Your Ref: EN010151
Our Ref: 23/0471/NSIP
Contact: Sylvia Bland
Email: [REDACTED]@n-kesteven.gov.uk

RE: Beacon Fen Energy Park DCO – Deadline 7 Submissions for North Kesteven District Council

ExQ3 BIO3.2 – NKDC’s comments on the updated Ecology Chapter (REP5-013/014)

Figure 7.3 Local Wildlife Sites within 2km
Document Reference: 6.4 ES Volume 3, 6.4.46
April 2025

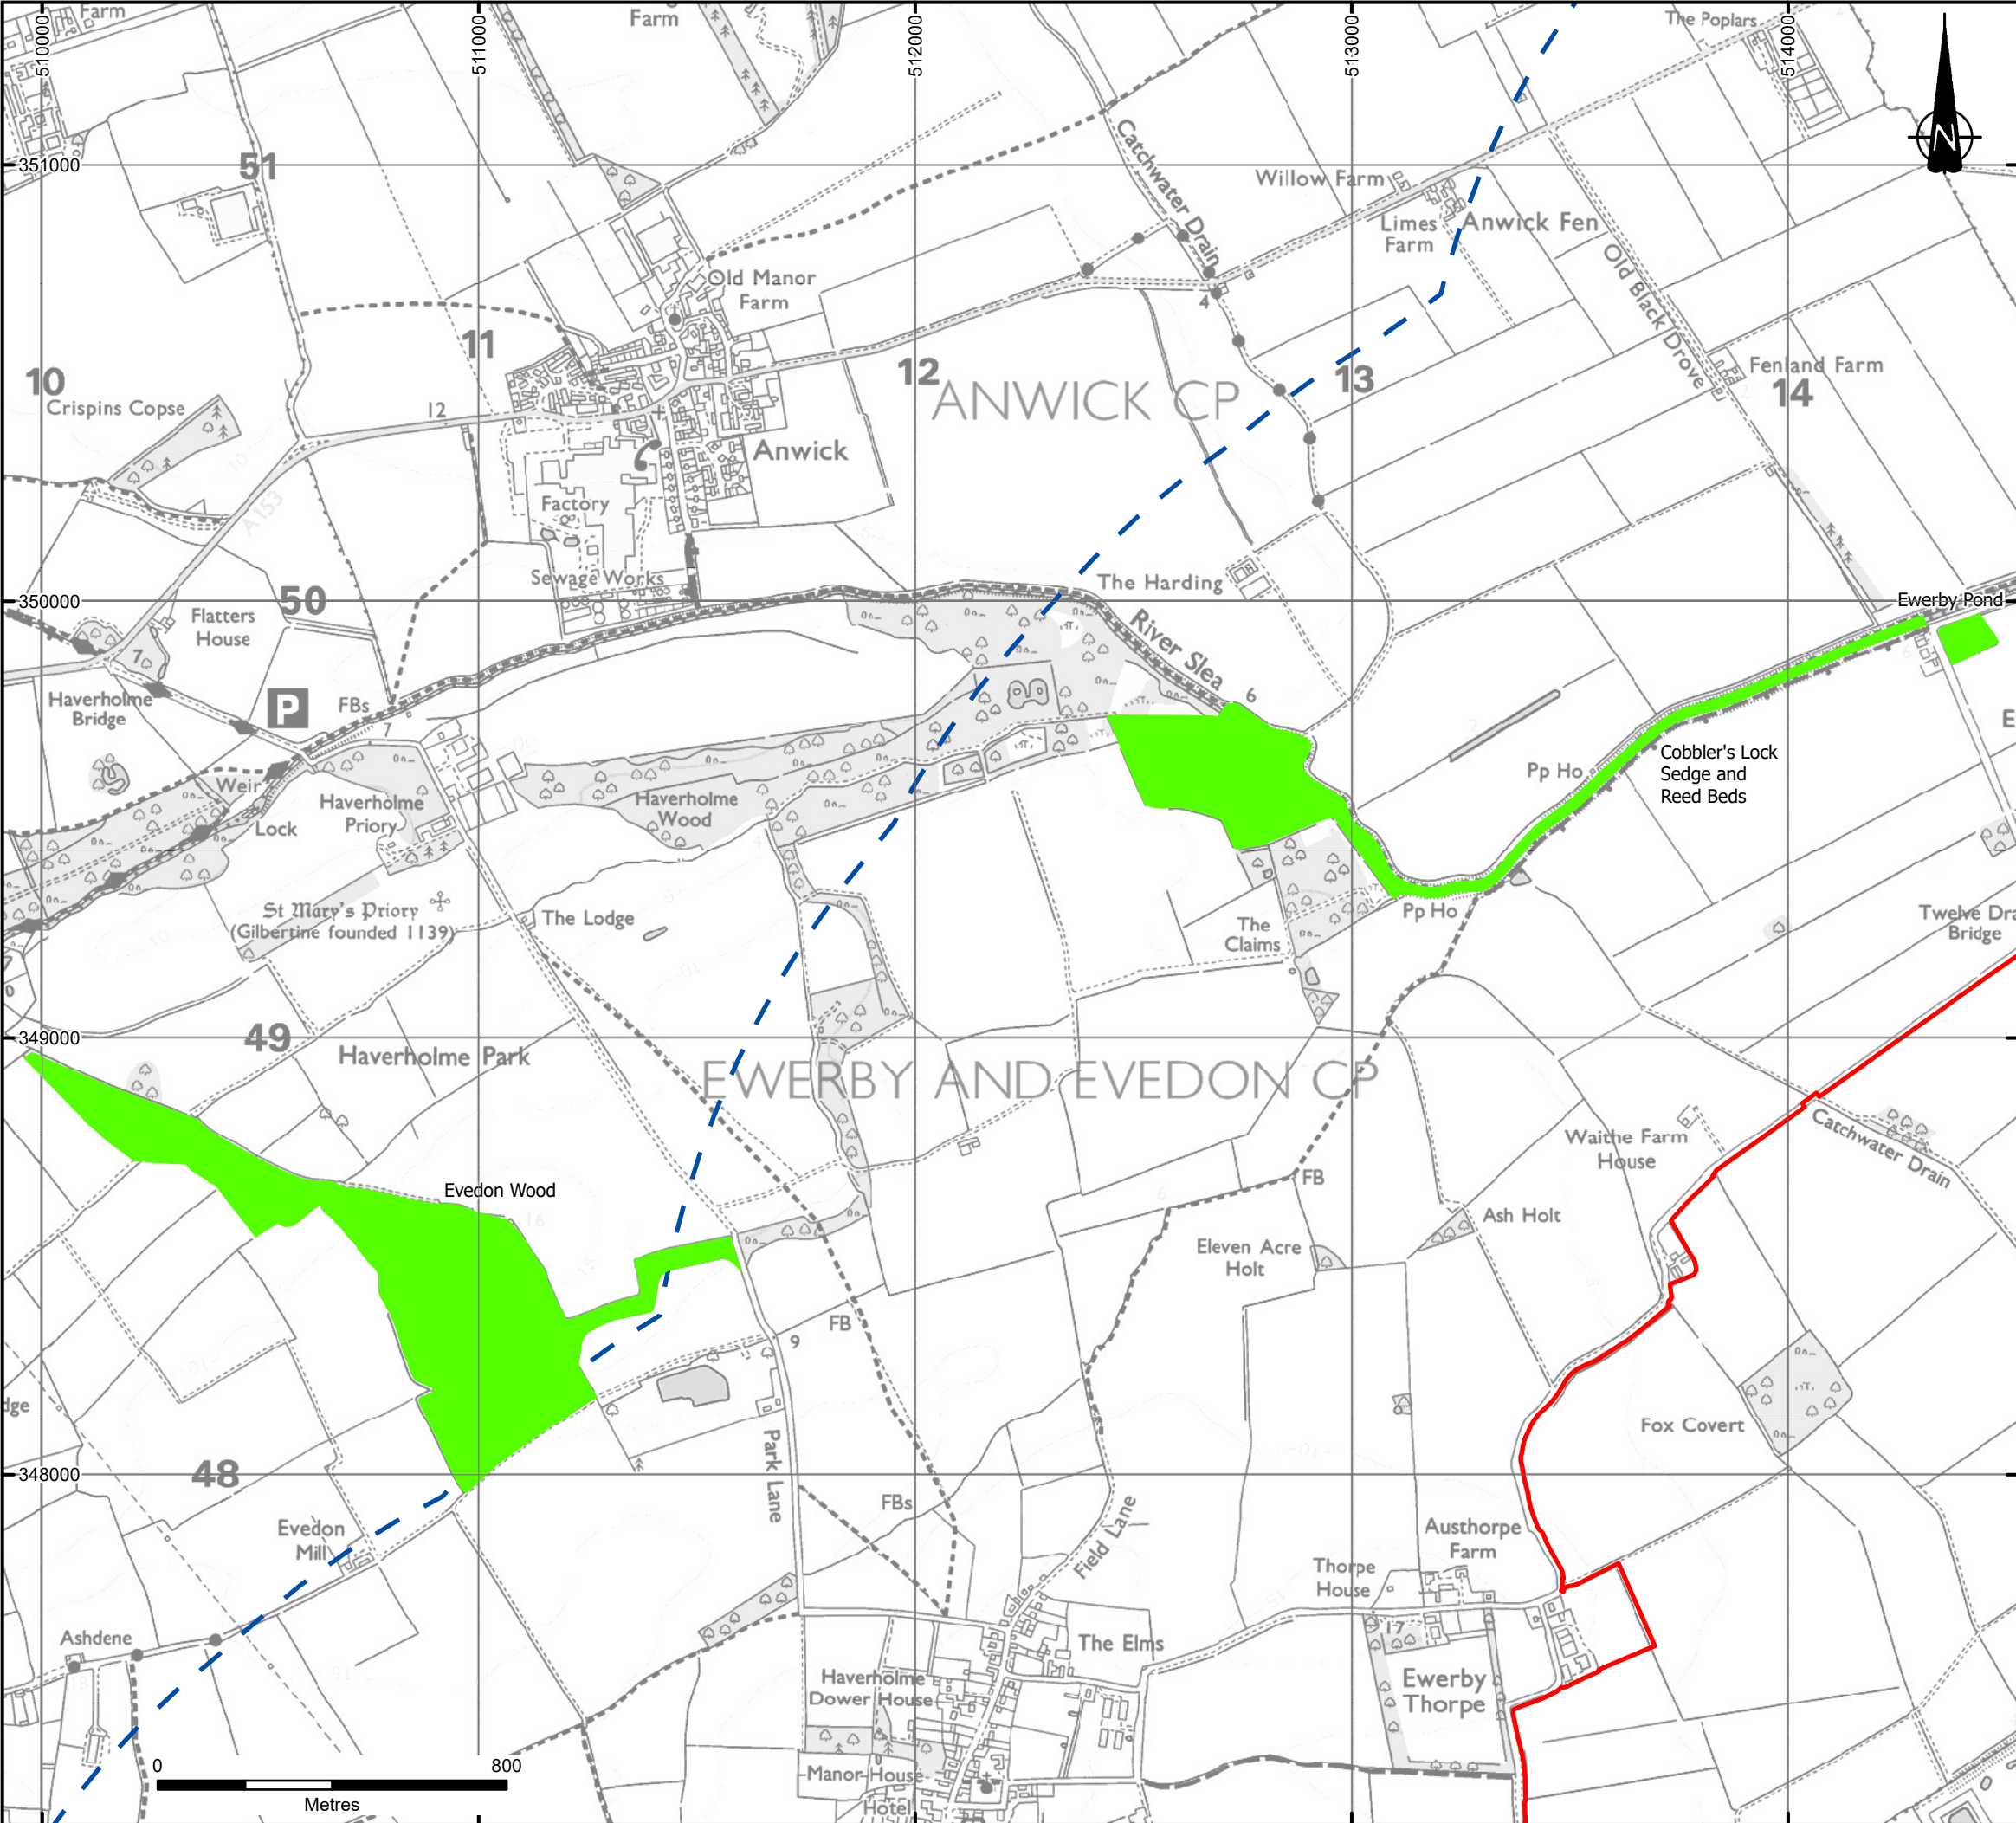
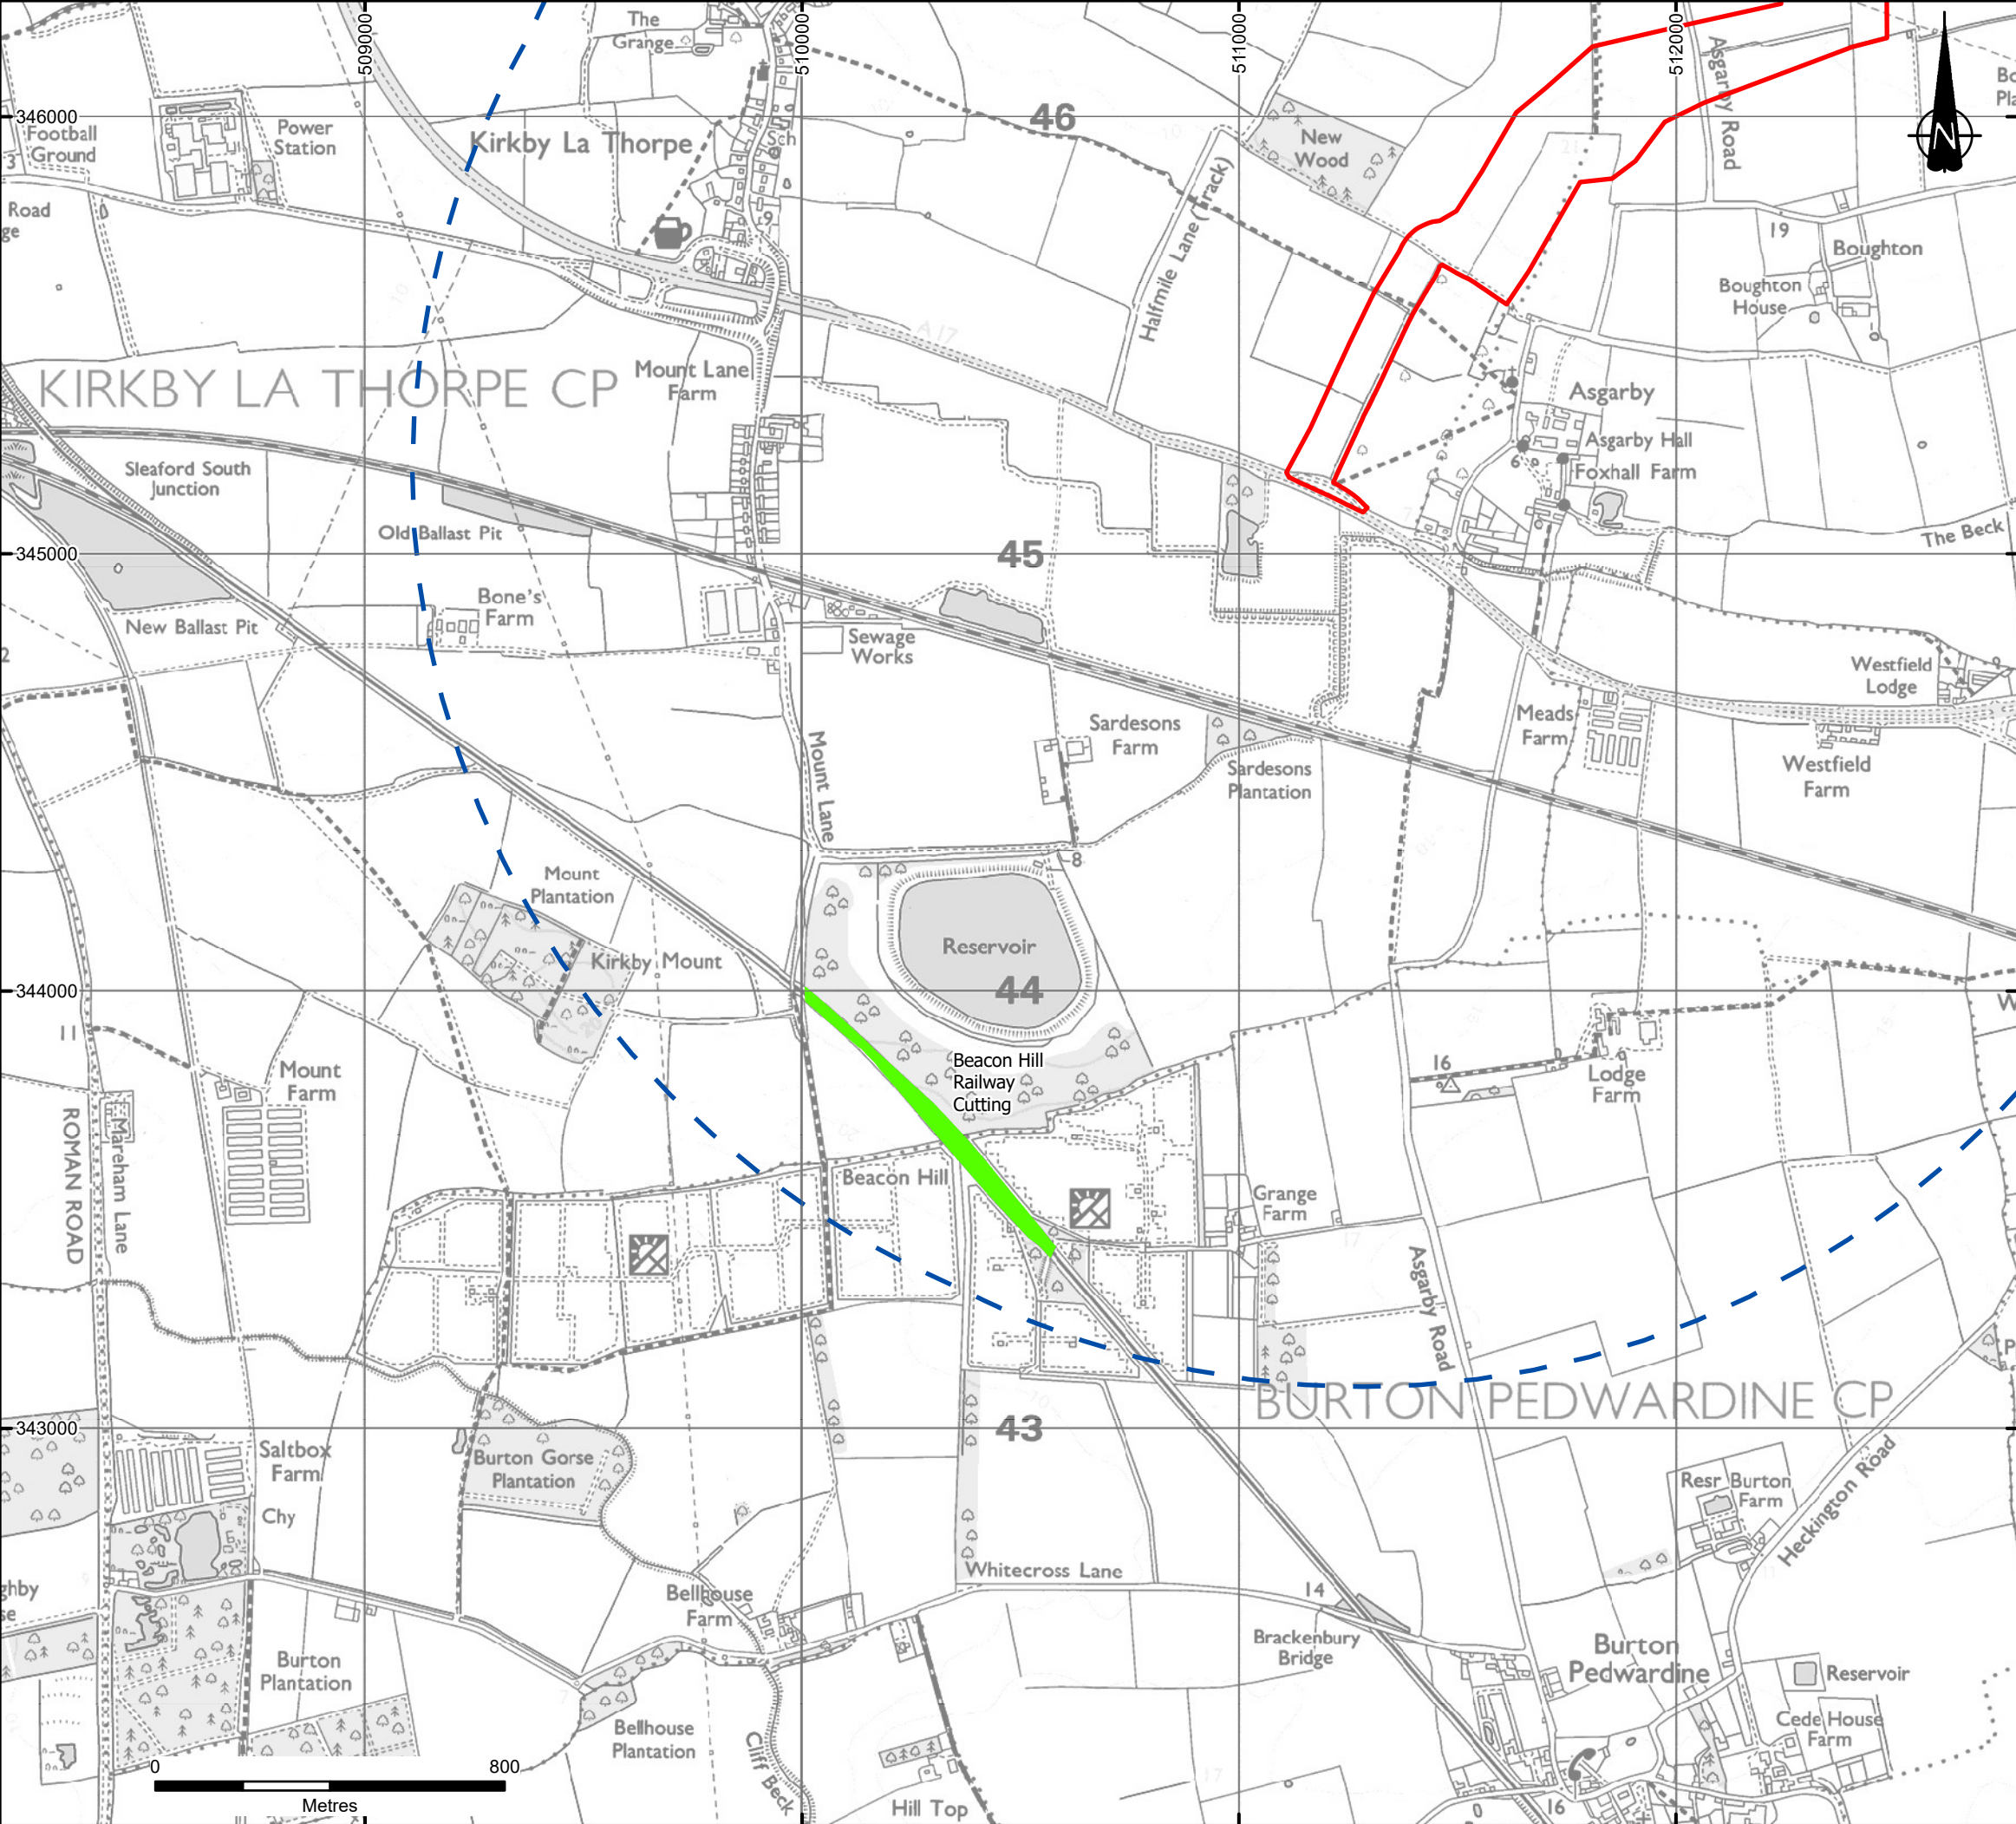
The impact on Great Hale Eau LWS seems to have been assessed without reference to specific baseline survey data (i.e. surveys relevant to the reasons for designation and aquatic habitats) and without a clear statement on the reasons for designation (this is not clearly identified elsewhere in the Chapter). There is also insufficient attention to whether this impact is avoidable, even though avoidance seems practicable (i.e. HDD, as committed elsewhere). Given this, there is an apparent conflict with Policy S60 of the Central Lincolnshire Local Plan.

This response overlooks the fact that a significant effect has been reported in relation to the Great Hale Eau LWS (paragraph 7.6.38 of REP5-014). It is irrelevant that the impact is subsequently mitigated to an acceptable level given the mitigation hierarchy needs to be addressed, as identified above, and this requires avoidance to be considered first.

- A new impact is identified in relation to Great Hale Eau LWS. As noted and discussed above, the applicant does not demonstrate a mitigation approach that responds to Policy S60 of the Central Lincolnshire Local Plan. It is not agreed that the mitigation hierarchy has been adequately applied. There are methods available to the Applicant that would avoid the impact (HDD or similar) and that are committed elsewhere for other watercourse crossings. The mitigation offered in Table 7.9 of REP5-013/014 focusses on restoration of bank habitats, but it is not clear this mitigation adequately responds to the reasons for designation as these are not clearly stated within REP5-013/014.
